2024/0704

Change of use to 2 no. retail units at ground floor and 4 no. flats to first floor

10 - 16 High Street, Wombwell, Barnsley, S73 0AA

PROJECT NO.	2025.00500.000	DWG NO.	PL002
SCALE	1:50 / 100 @ A1	REV.	-

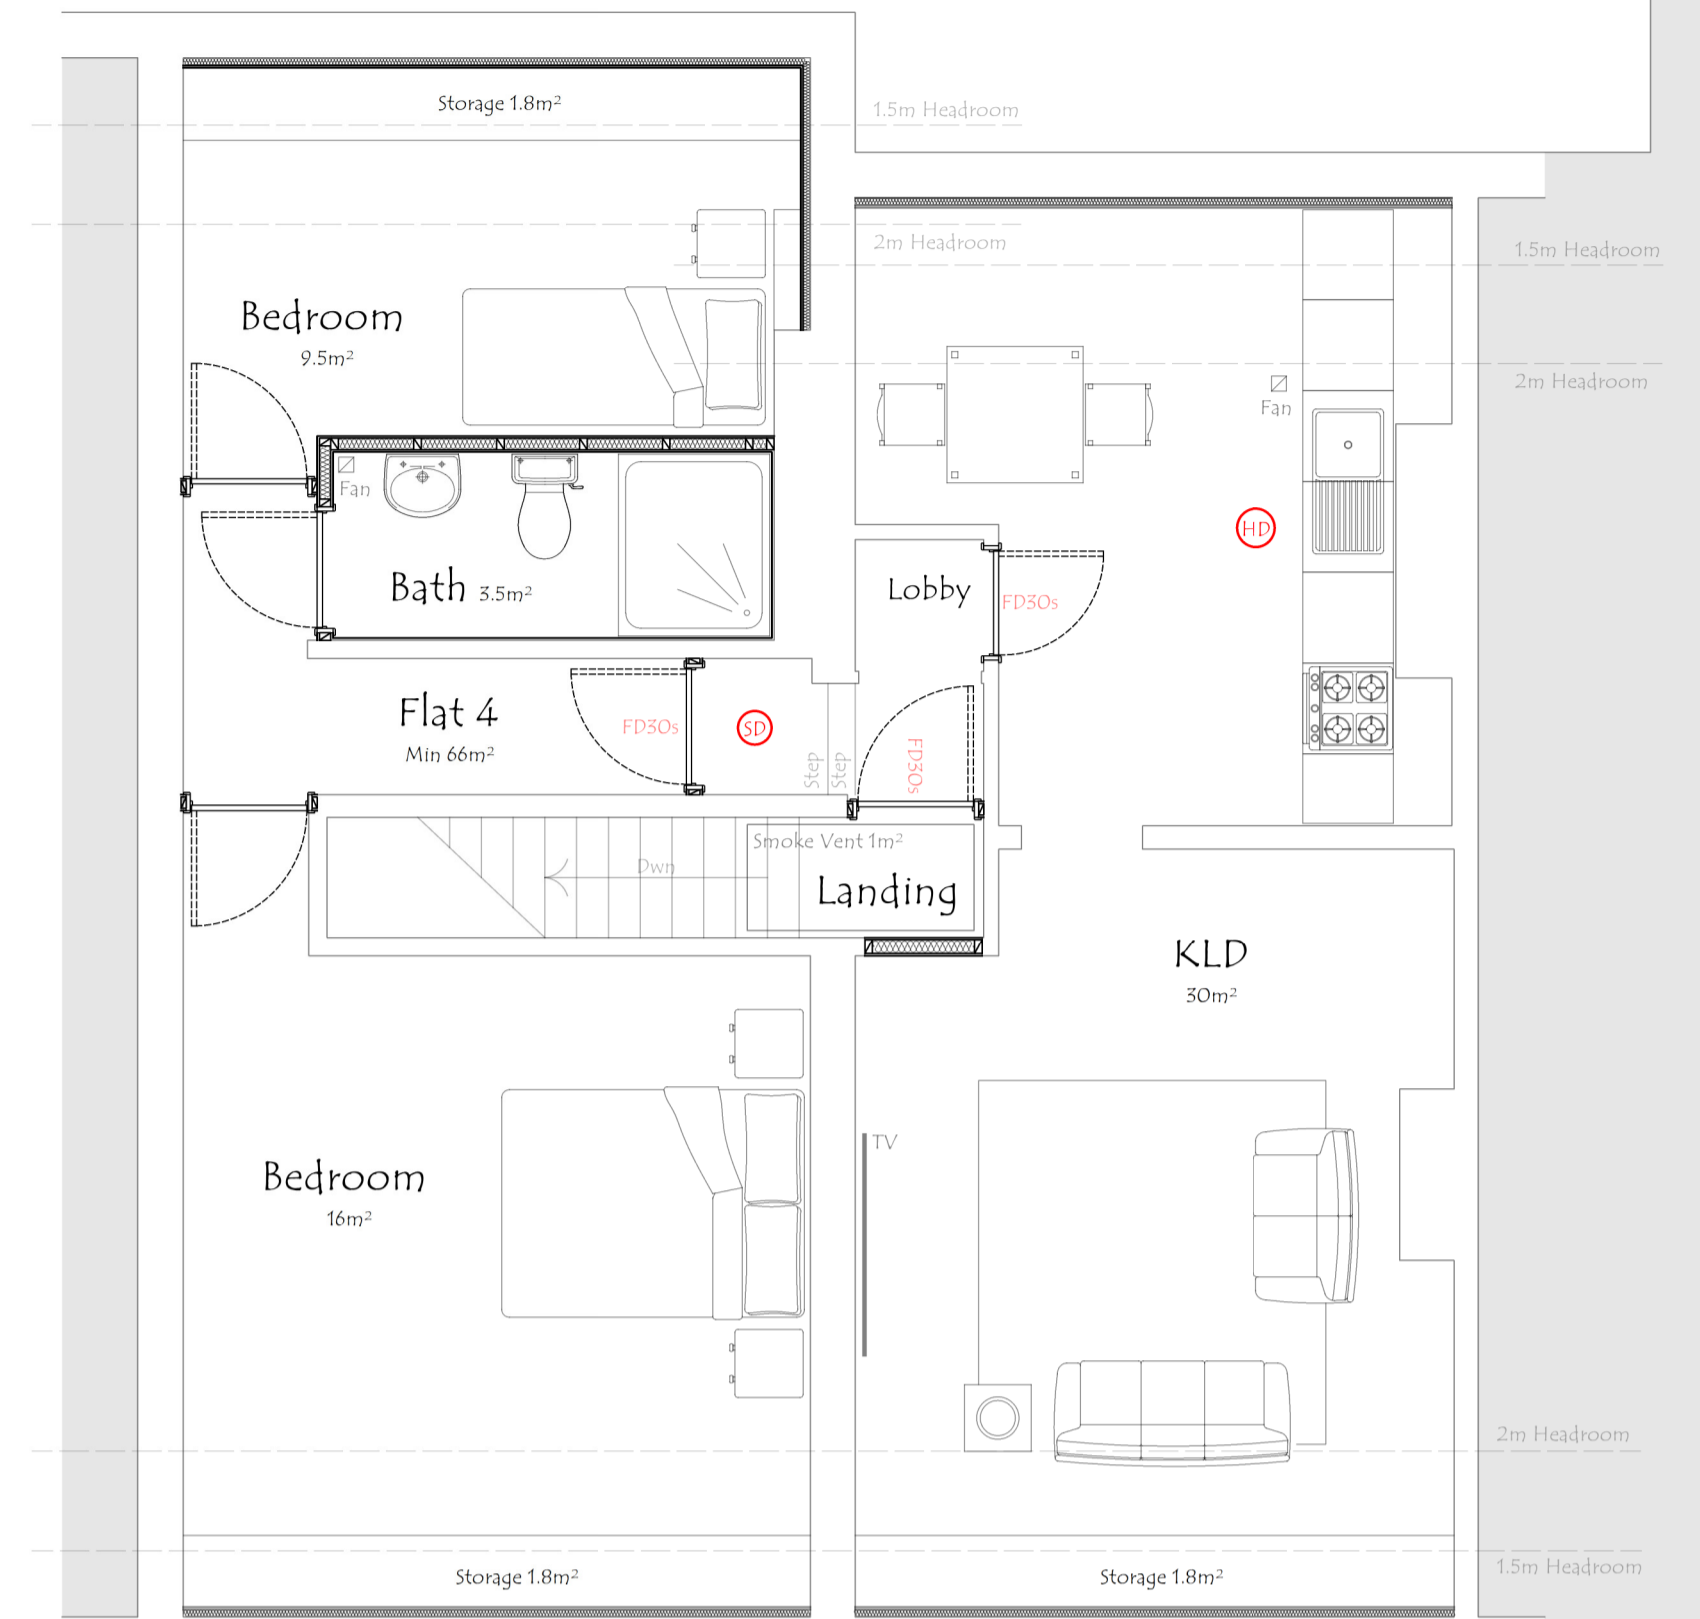
In terms of cycle storage and bin storage, an amended site layout plan (drawing no. PL002 Rev. A) has now been submitted which addresses previous concerns insofar as cycle parking facilities are provided for the retail units along with sufficient bin storage areas, and both retail units are now shown to have access to the rear service yard.
